MEMORANDUM

FROM: Jim Wendel, Development Review Coordinator

DATE: January 2, 1997

RE: Site Plan Amendment
168 Curtis Road

- ▶ TITLE: SCHEMATIC GRADING
- ▶ PERMIT ISSUED WITH REQUIREMENTS
- ▶ JOB #: 2718.4
- ▶ EXHIBIT #: 1-7

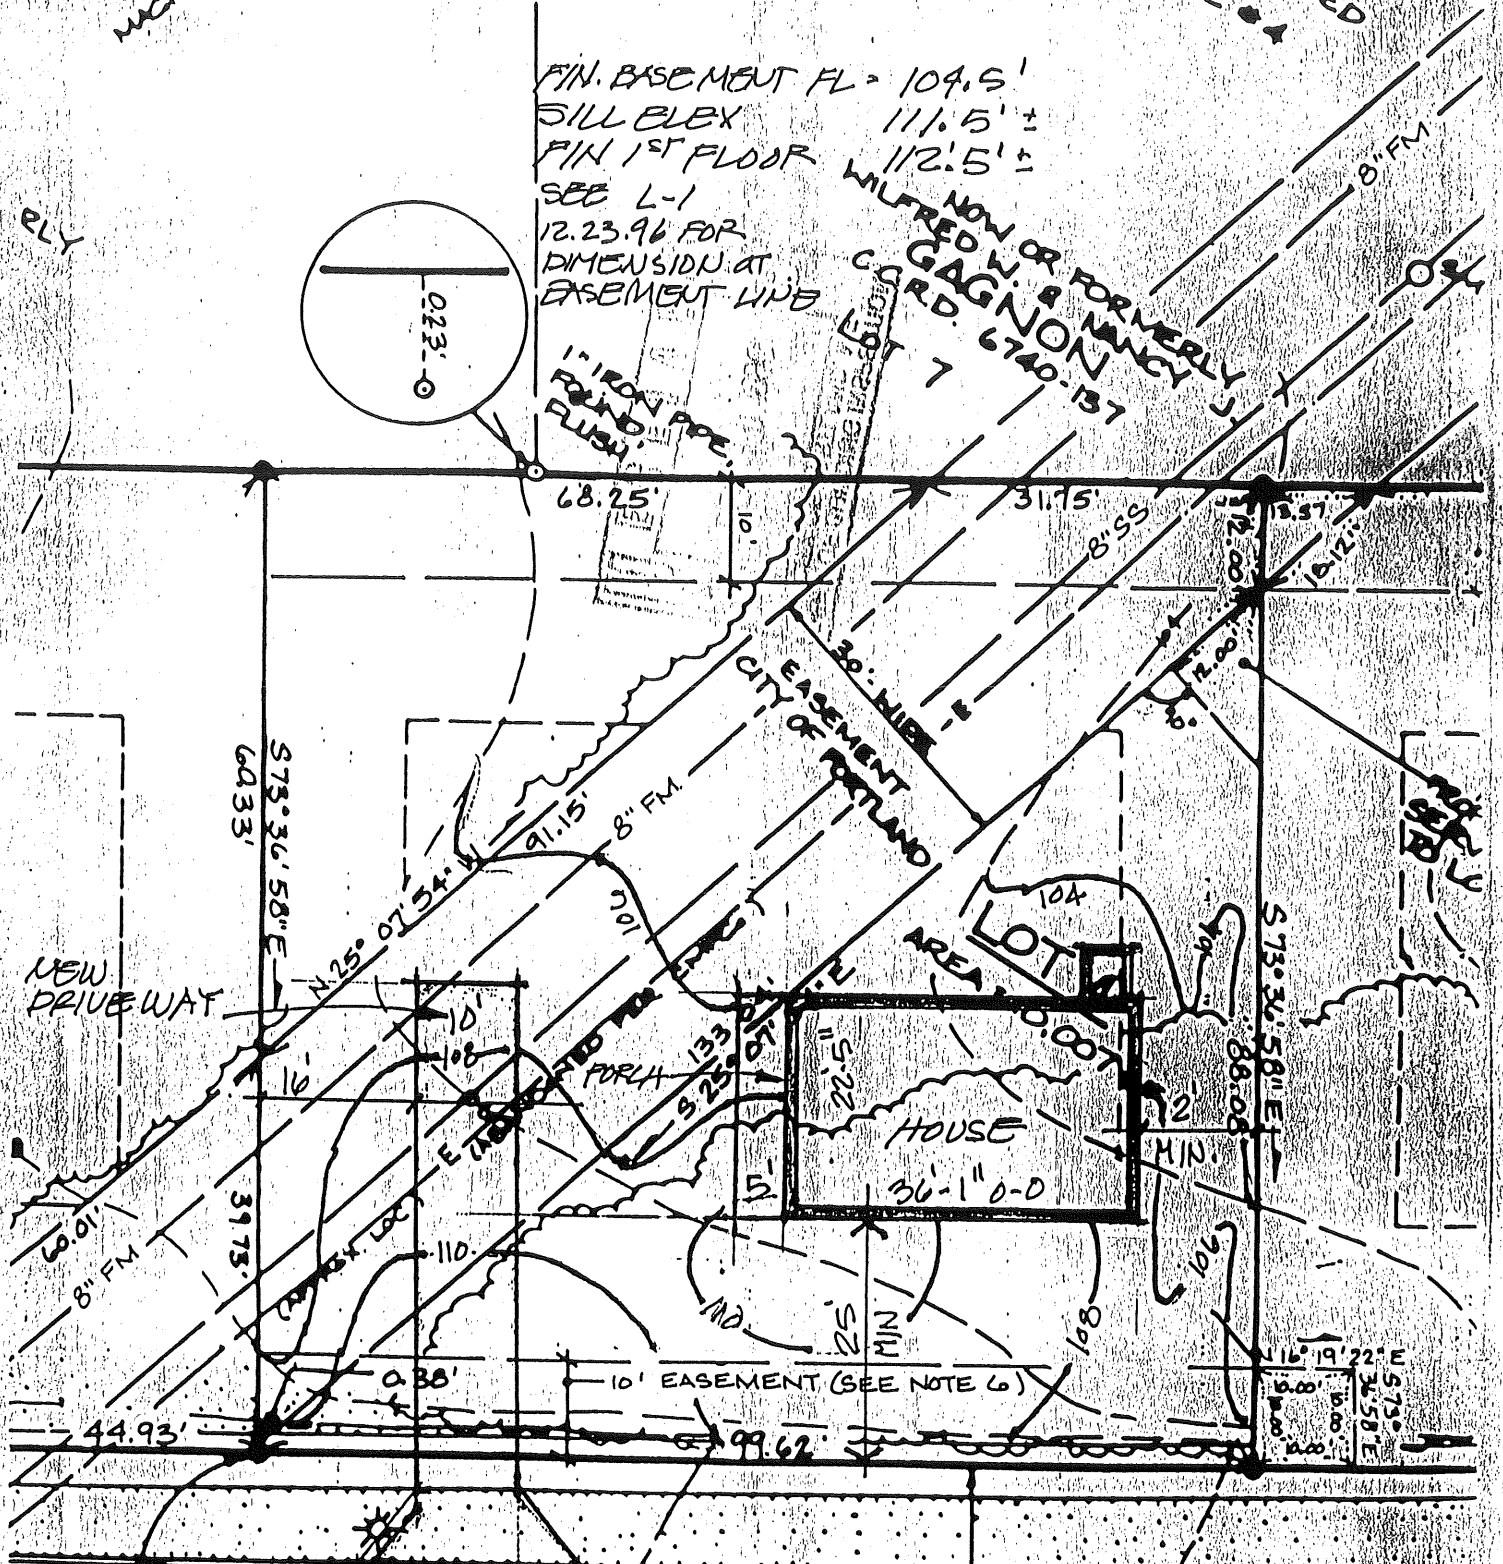
On December 31, 1996 I reviewed the amended site plan for 168 Curtis Road. From a drainage point of view the reduction of the right side yard dimension to 12' will not negatively impact drainage on site or on the abutting lot. There is sufficient side yard space to properly construct the swale.
